4th September 2023

To Kirklees Planning Department 2023/92327 - 2023/92555 – 223/92254 – 2023/92253

Drawing Title
Construction Management Plan

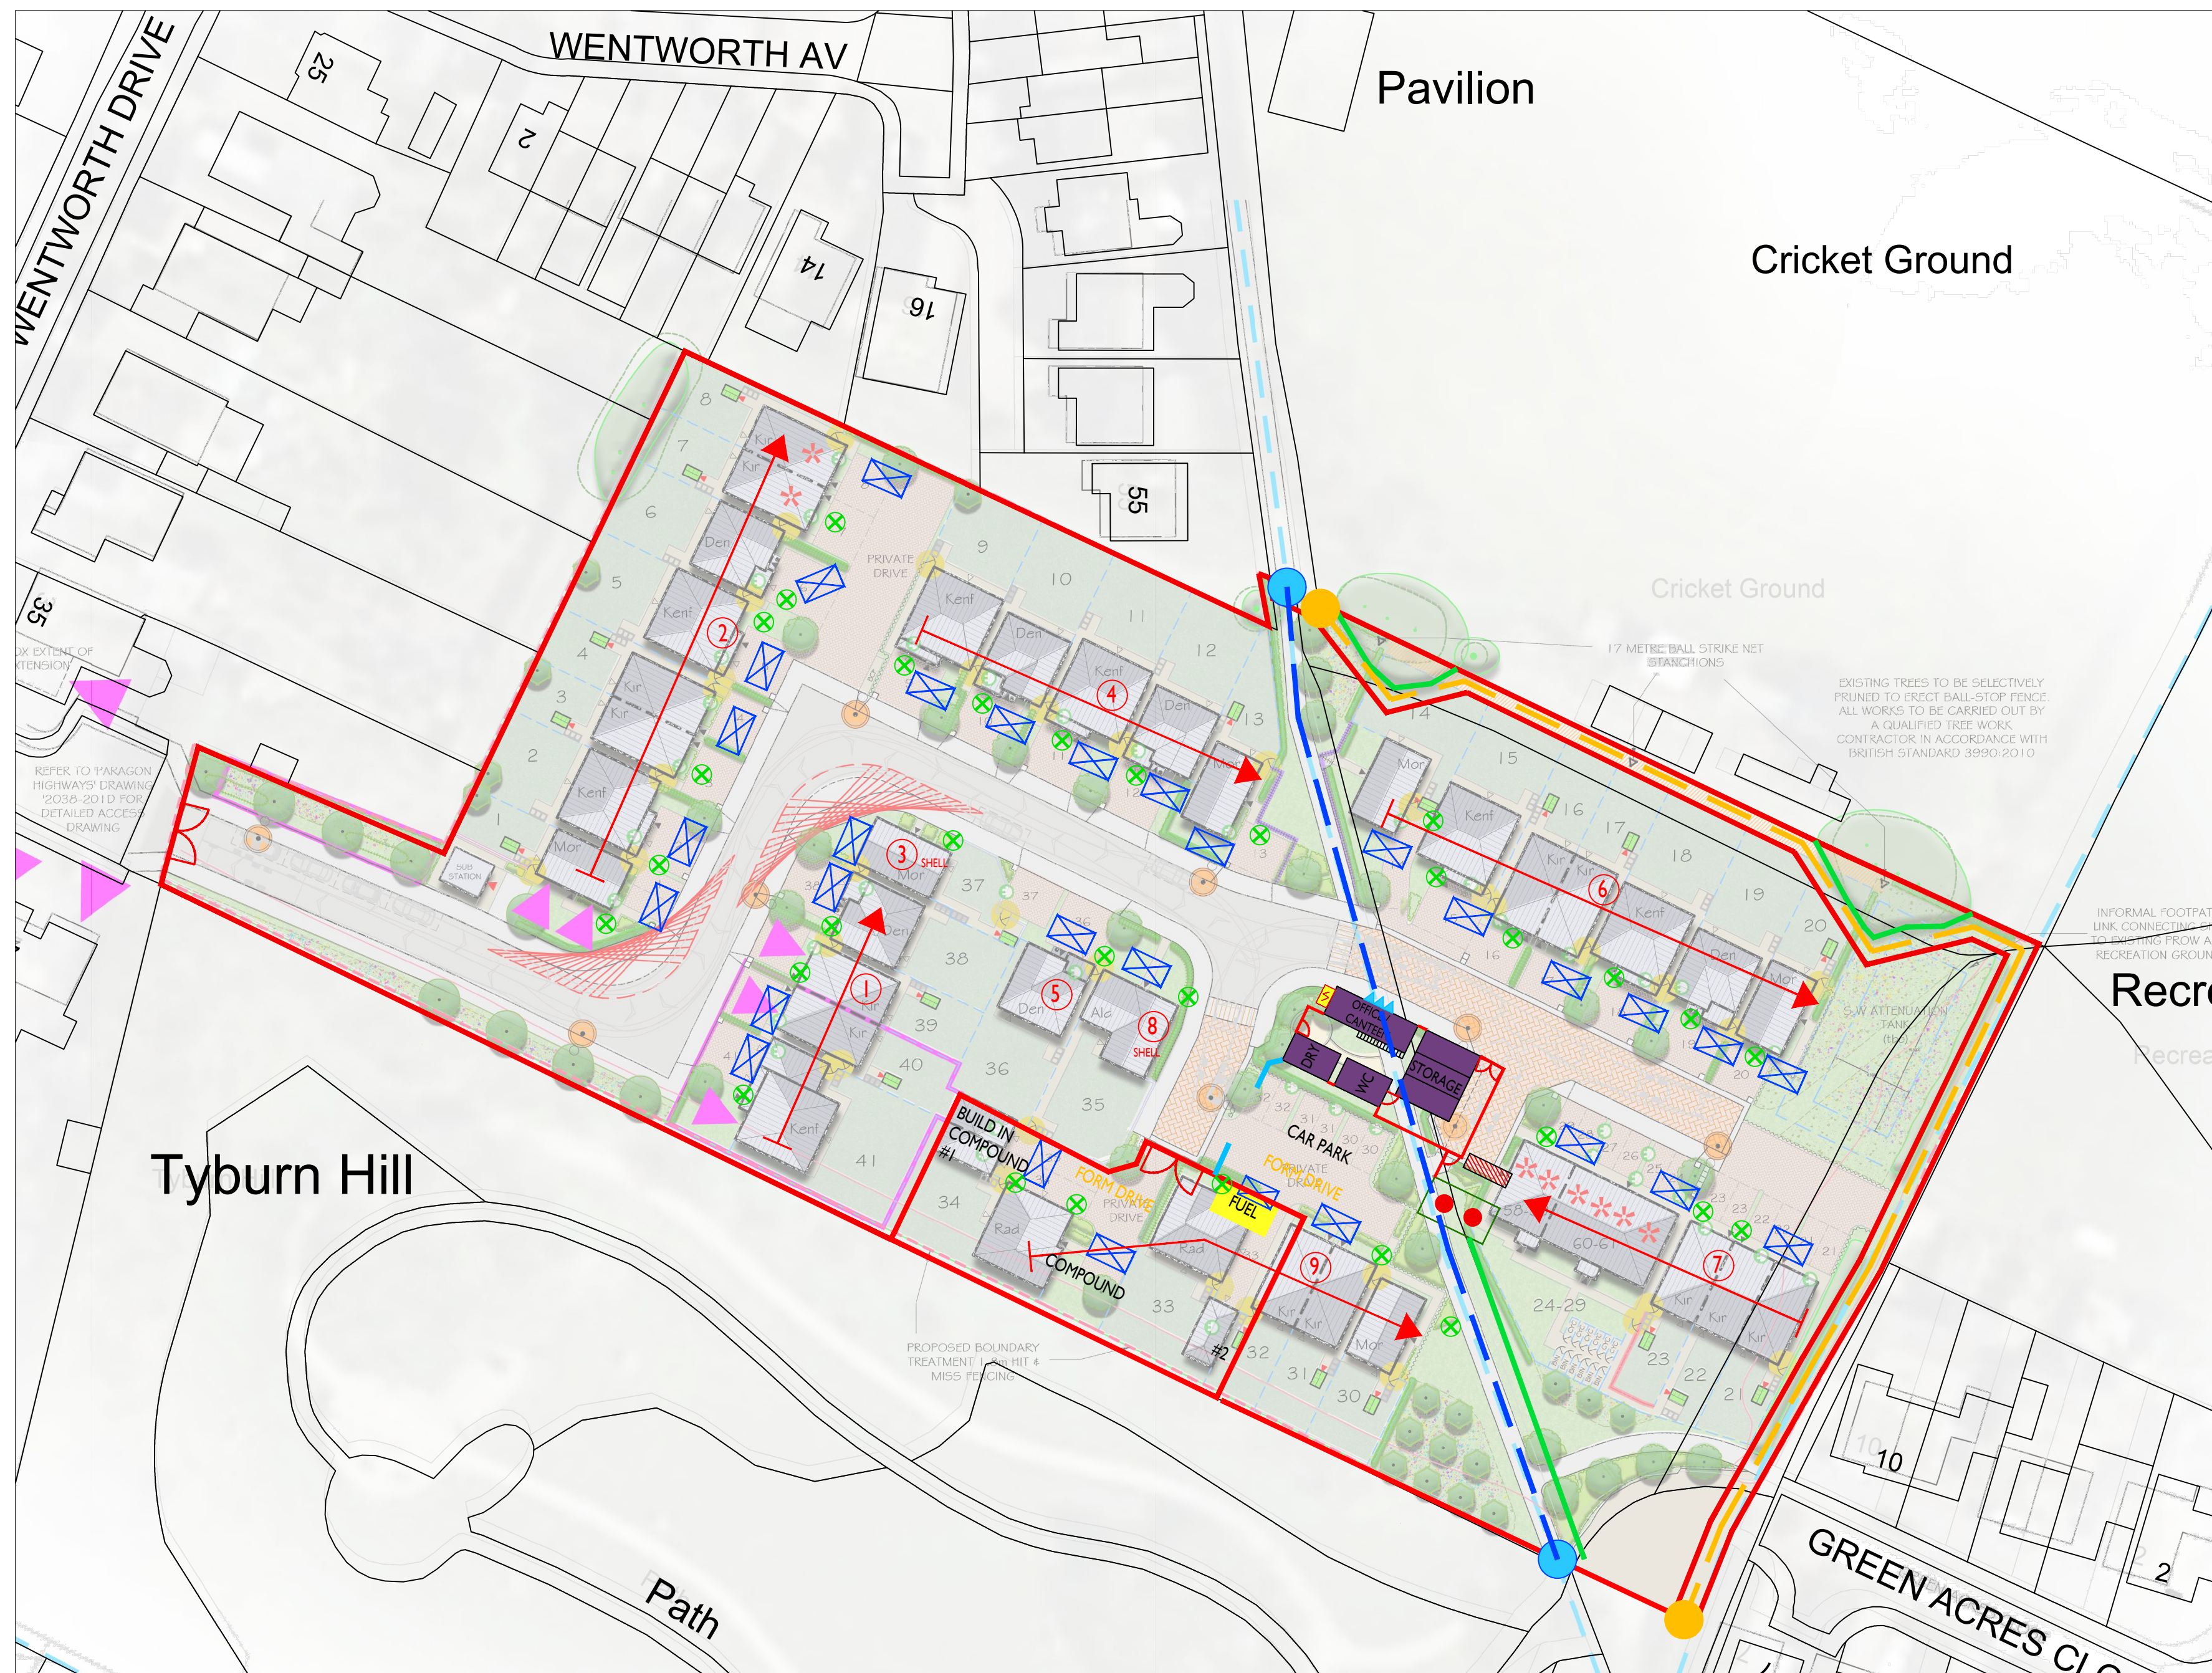
Once again Newetts ignored agreed action made with planning about accessing the site and entered the site via Warburton and Green Acre Close. Are Newetts liaising with planning or just riding rough shod, not respecting the importance of good relationships with villagers?
